CITY OF ALBUQUERQUE

Re: VCA Vet Care Hospital
8850 Holly Ave NE
Traffic Circulation Layout
Engineer's/Architect's Stamp 09-14-2021 (C20-D071)

Based upon the information provided in your submittal received 09-14-2021, the above referenced plan cannot be approved for Building Permit until the following comments are addressed:

TCL-001

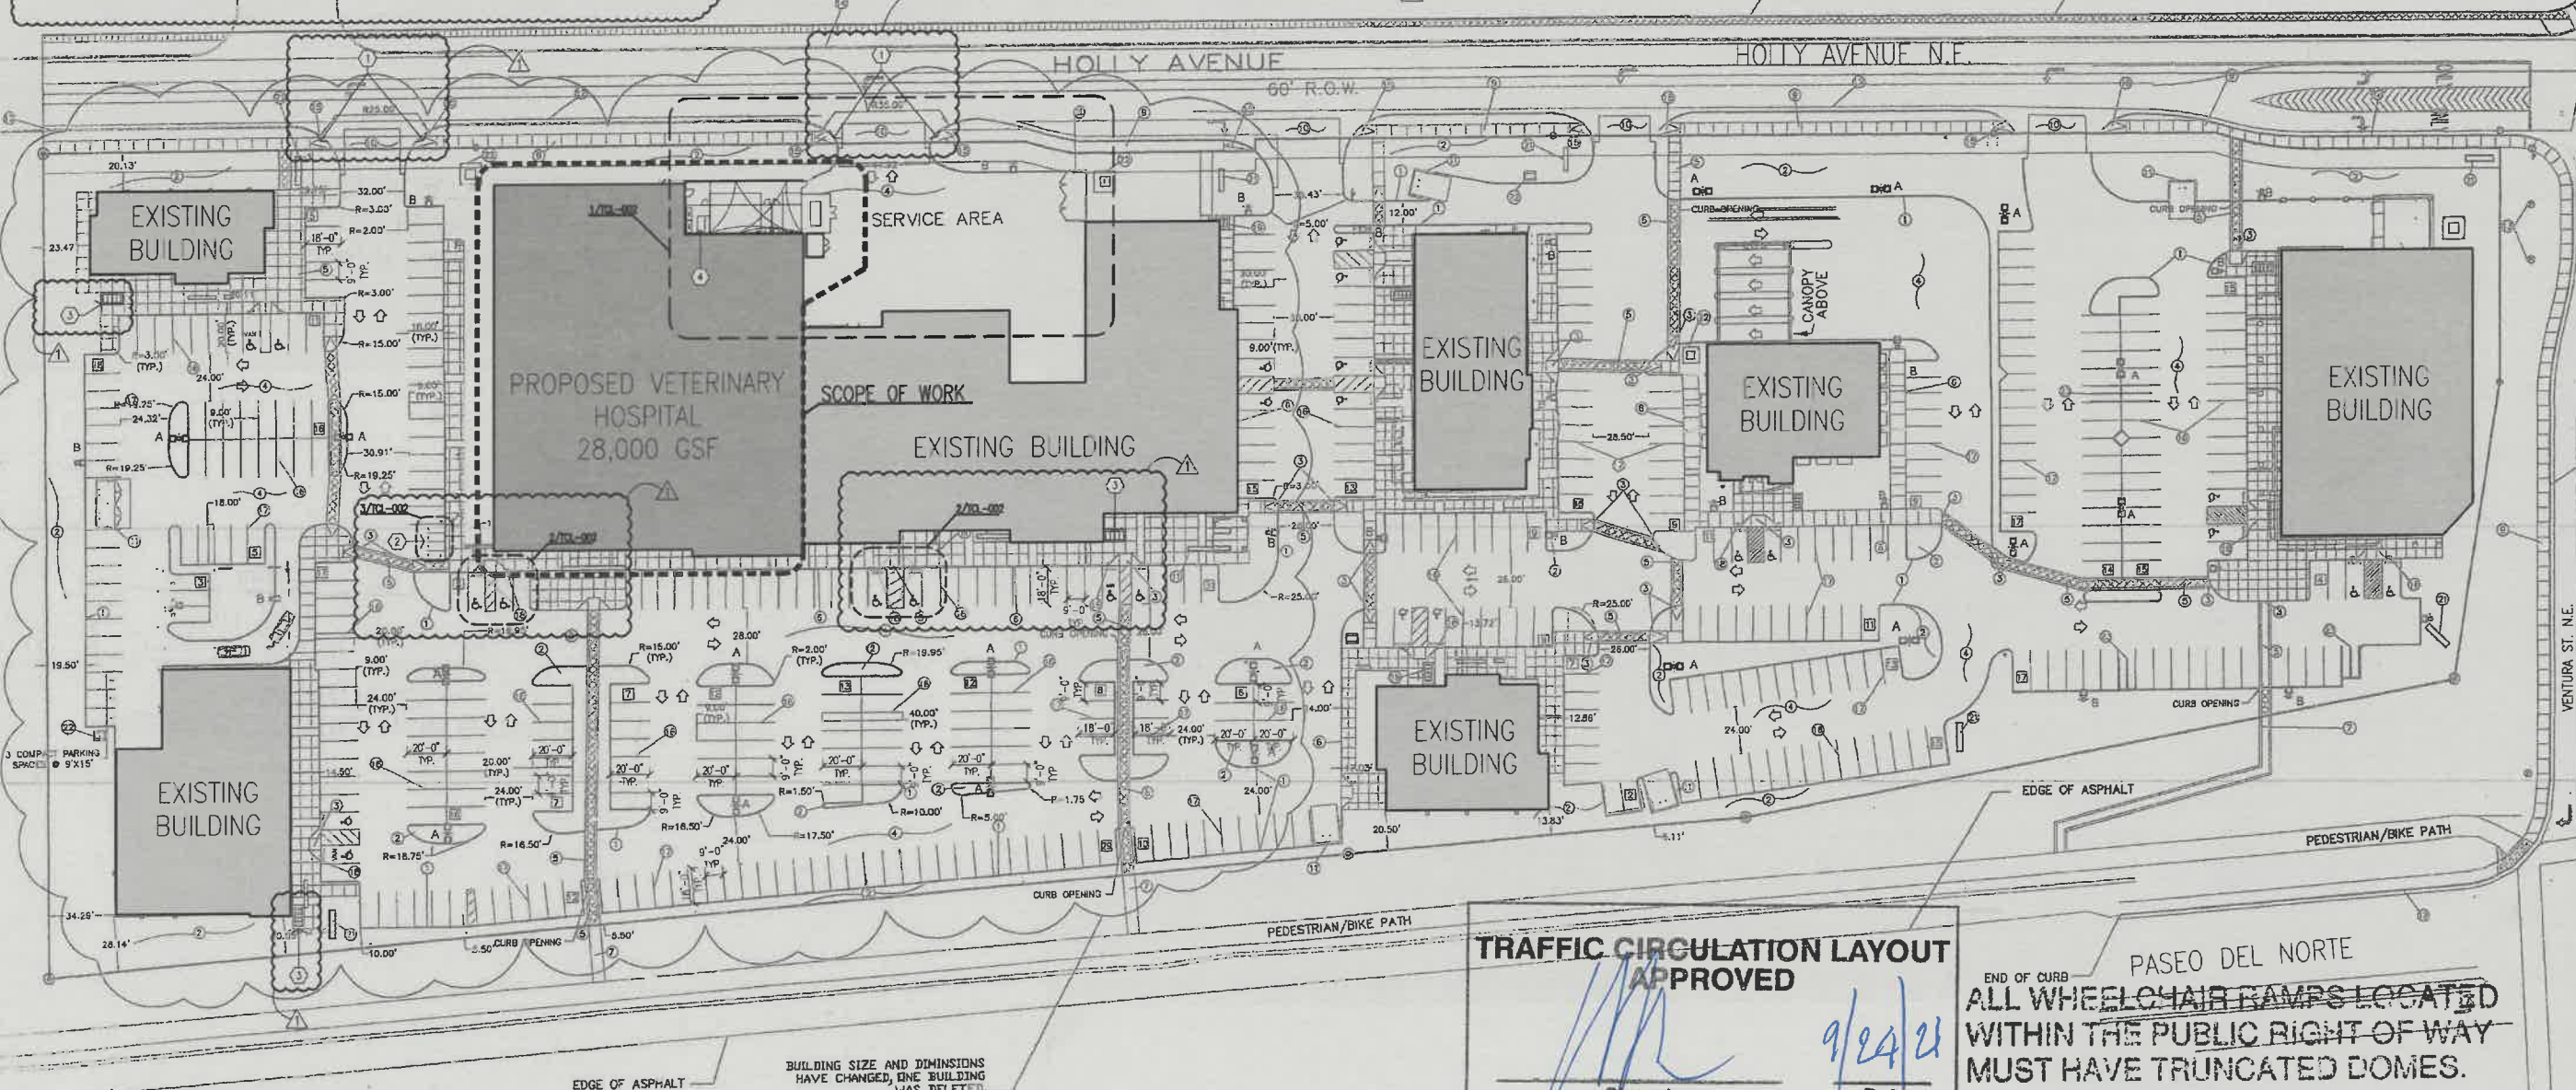
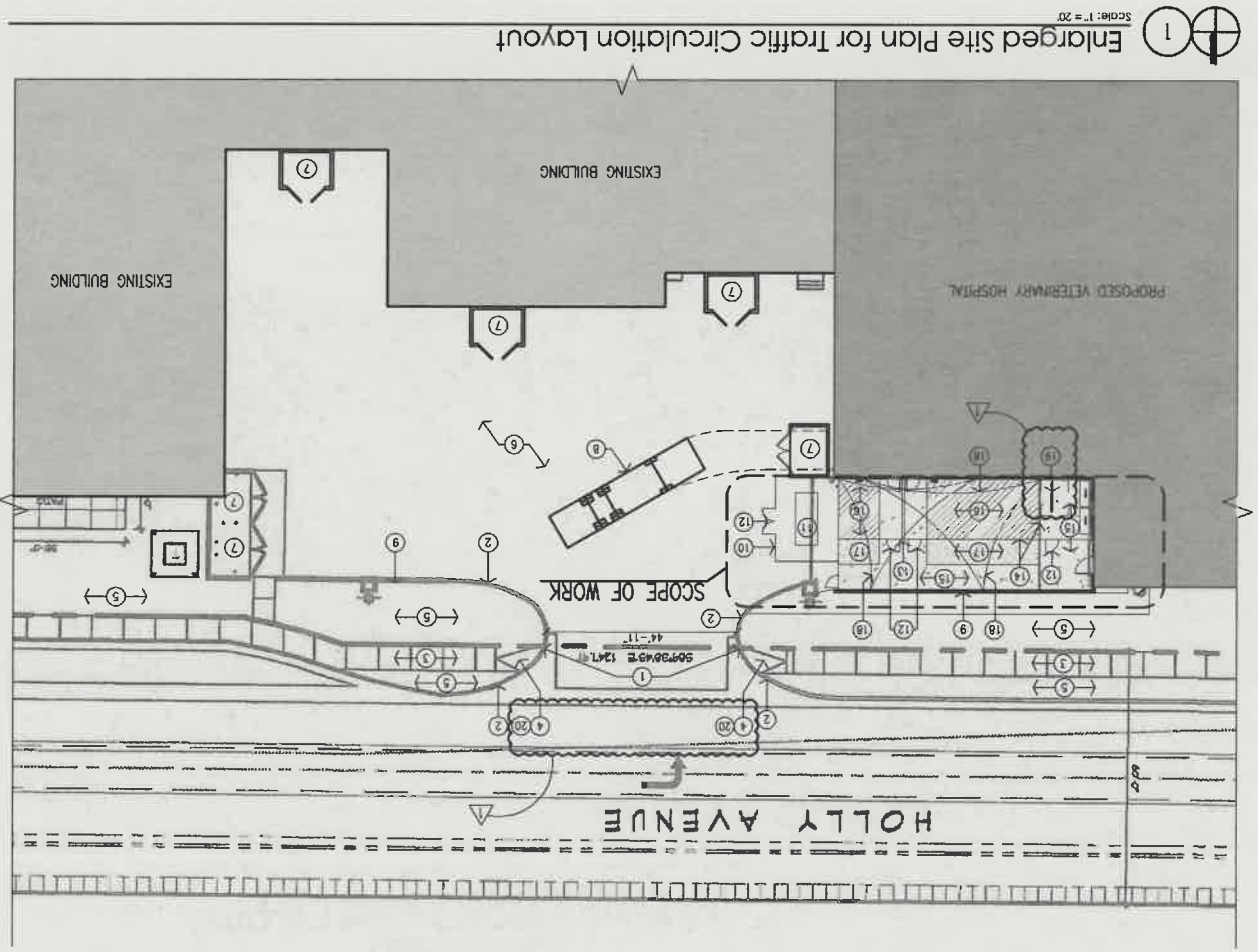
1. Please show a vicinity map showing the location of the development in relation to streets and well known landmarks.
2. Listed are the number of parking spaces required by the IDO as well as the proposed number of parking spaces including bicycle and motorcycle parking. Coordinate/discuss with Zoning.
3. Please identify all existing buildings, doors, structures, sidewalks, curbs, drive pads, wall and anything that influences the parking and circulation on the site.
4. Please list the width and length for all existing and proposed parking spaces. Some dimensions are not shown.
5. The minimum parking stall dimensions are:

6. The ADA accessible spaces must include an access aisle. Van accessible aisles should be 8ft wide; all others should be 5ft wide.
7. The ADA accessible parking sign must have the required language per 66-7-352.4C NMSA 1978 **"Violators Are Subject to a Fine and/or Towing."** Please call out detail and location of signs.
8. The ADA access aisles shall have the words **"NO PARKING"** in capital letters, each of which shall be at least one foot high and at least two inches wide, placed at the rear of the

parking space so as to be close to where an adjacent vehicle's rear tire would be placed.
(66-1-4.1.B NMSA 1978)

9. ADA curb ramps must be **updated to current standards and have truncated domes** installed:
 - Entrance ramps (Holly AVE.)
 - Ramps for ADA parking stalls.

10. Motorcycle parking spaces shall be designated by its own conspicuously posted upright sign, either free-standing or wall mounted per the zoning code. Label pavement MC.

15. Per the IDO, a 6 ft. wide ADA accessible pedestrian pathway is required from the public sidewalk to the building entrances. Please clearly show this pathway and provide details.

16. Per DPM, a 6 ft. wide ADA accessible pedestrian pathway is required from the ADA parking stall access aisles to the building entrances. Please clearly show this pathway and provide details.

SHEET
TCL-003

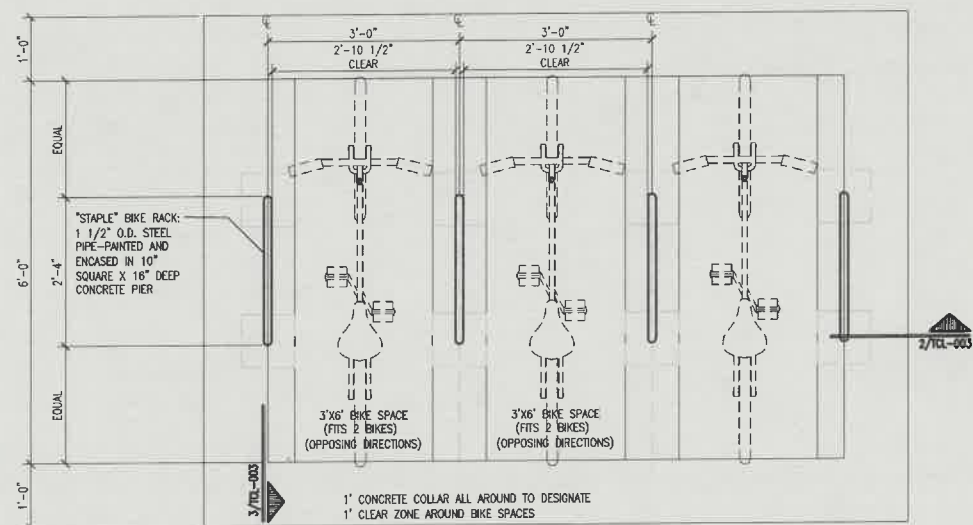
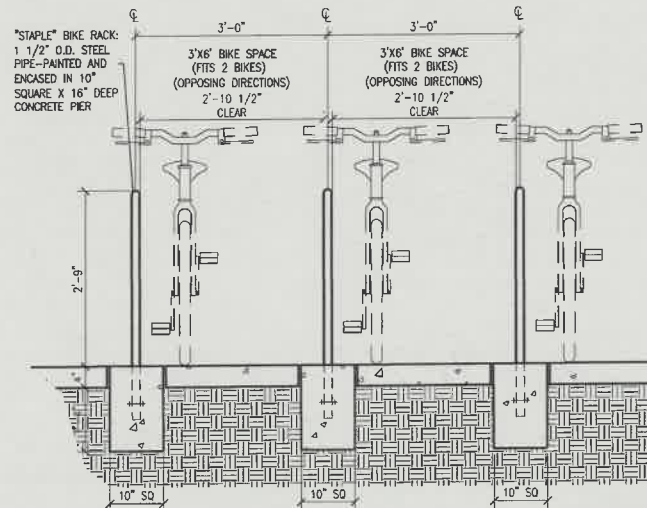
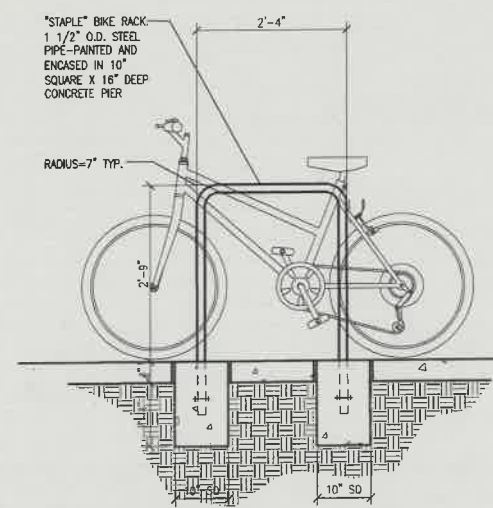
11. All bicycle racks shall be designed according to the following guidelines:
 - a. The rack shall be a minimum 30 inches tall and 18 inches wide.
 - b. The bicycle frame shall be supported horizontally at two or more places. Comb/toaster racks are not allowed.

- c. The rack shall be designed to support the bicycle in an upright position. See the IDO for additional information.
 - d. The rack allows varying bicycle frame sizes and styles to be attached.

- e. The user is not required to lift the bicycle onto the bicycle rack.
 - f. Each bicycle parking space is accessible without moving another bicycle.

12. Bicycle racks shall be sturdy and anchored to a concrete pad.
13. A 1-foot clear zone around the bicycle parking stall shall be provided.
14. Bicycle parking spaces shall be at least 6 feet long and 2 feet wide.
